Planning and Development Service
Economy and Infrastructure
PO Box B93, Civic Centre 3,
Off Market Street, Huddersfield, HD1 2JR

Date: 12-Apr-2021
Our Ref: 2021/90361

**Discharge conditions 3, 5, 7-14, 16, 18 on previous permission 2020/91376 for
erection of D2 (leisure building) and B1c /B8 (starter unit/trade counter building)
Land adj, 260, Bradford Road, Batley, WF17 6JD
Application Number: 2021/90361**

Figure B-1
Measurement Location Plan

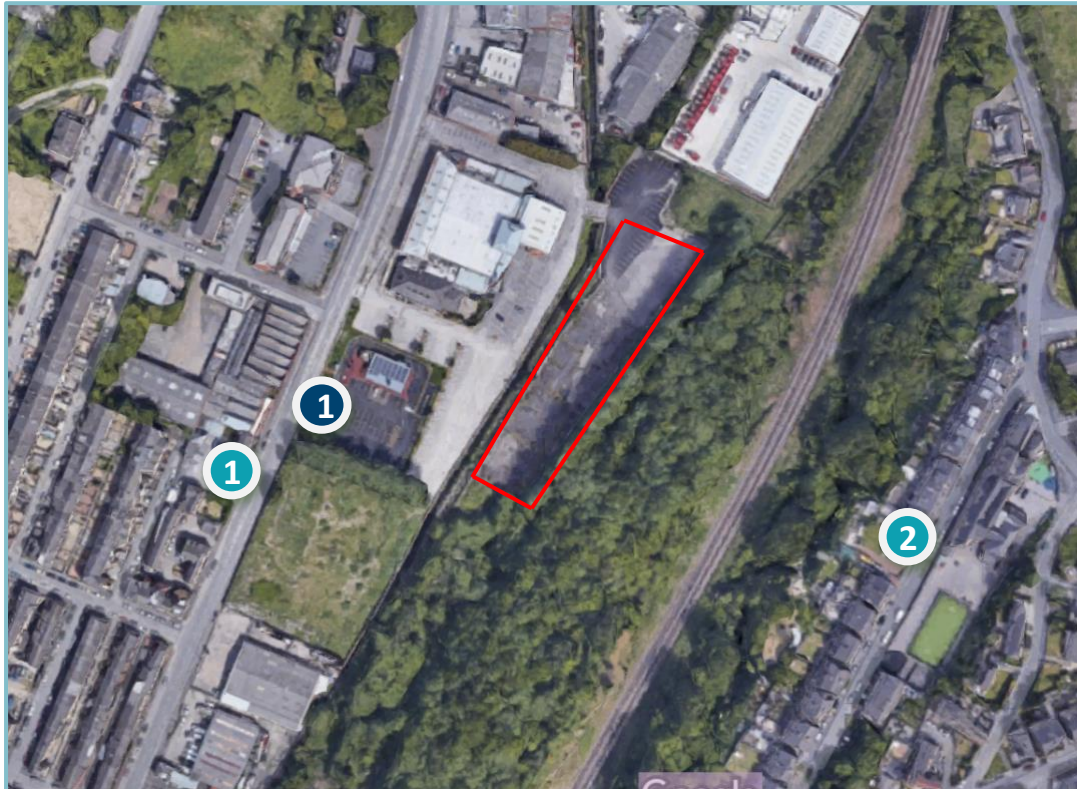
Para 4 of the report states that due to the Covid 19 restrictions brought into force in England on the 5th of January 2021, no specific noise survey has been completed for this development. In the absence of any site specific measured noise data, noise levels from a noise assessment completed by ADC Acoustics for the 'Starbucks Drive' Thru Coffee Shop, located at the southern end of the development site (ref: ARR/C/2565.35 dated 18th September 2019 and submitted to Kirklees Council as part of a discharge of conditions application (ref: 2019/44/92988/E)), have been utilised. Whilst reference has been made to the Association of Noise Consultants (ANC) and the Institute of Acoustics (IoA) Joint Guidance on the Impact of COVID-19, it should be noted that it was, and still is, possible to conduct noise surveys in a COVID compliant manner.

The Dragonfly report states that as there is currently insufficient detail available as to the type, size and exact location of the fixed plant to permit a detailed assessment, limits will be provided for the maximum allowable plant noise levels at the nearest noise sensitive receptor, based on the lowest background noise levels. However, the ADC Acoustics report advises that the predicted levels are based on mitigation provided by a 2m high solid close boarded fence (12mm thick) around the plant compound and along the southern boundary of the site and this is not referred to in the Dragonfly report. Clarification is sought on whether the ADC Acoustics mitigation measures are applicable to this site too.

The report fails to meet the requirements of condition 18 therefore it should not be approved. There is no reference to permission from ADC Acoustics to use the report and based on the uncertainty of the report and the levels referred to within it, I recommend that the condition is not discharged at this moment.
